Application No: R/108/21/PL
Site Address: 117 Sea Lane Rustington BN16 2RU
Description of works: Demolition of two dwellings and the construction of 3 No. 3-bed town houses and 5 flats. This site is in CIL Zone 4 and is CIL Liable as new dwellings.

Thank you for your internet representation made on 19th November 2021 which has been recorded as an objection with the comments as follows:

My objections to the revised plan are as before, but in addition:

A REV	27/10/21 DATE	Second floor removed. DESCRIPTION	18th Mar 2021		EL	
			DRAWING TITLE PROPOSED STREET ELEVATIONS 1			
			SCALE 1 : 100@ A1		DRAWING NO. P202

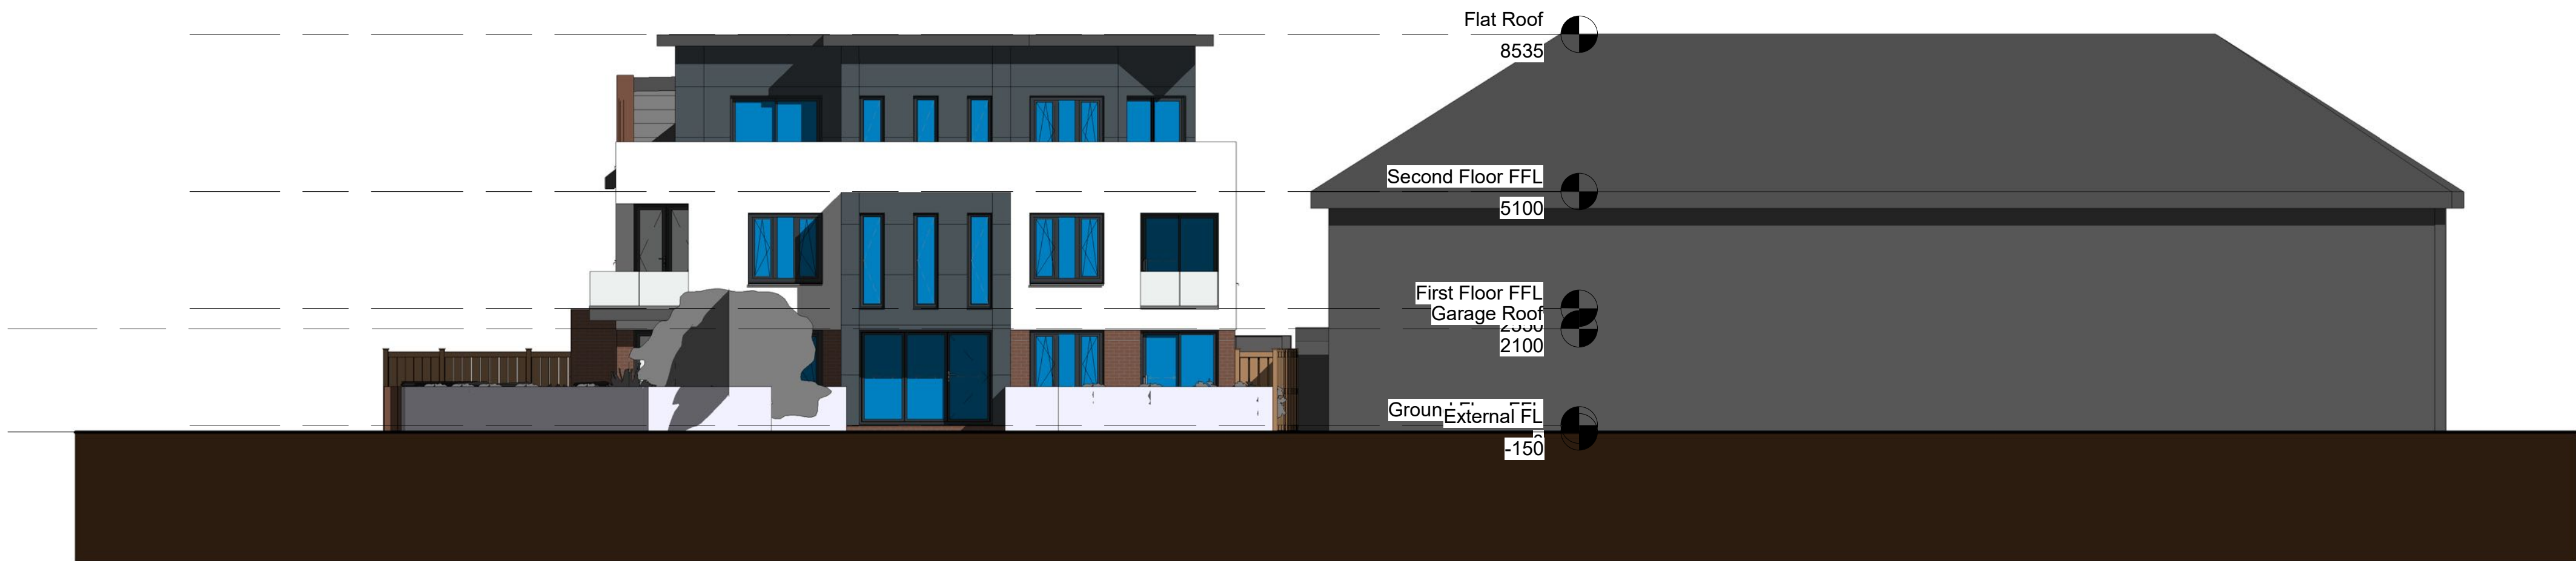
Density and height. Despite the reduction in height, the flats are still a solid flat-topped block 3 storeys high.
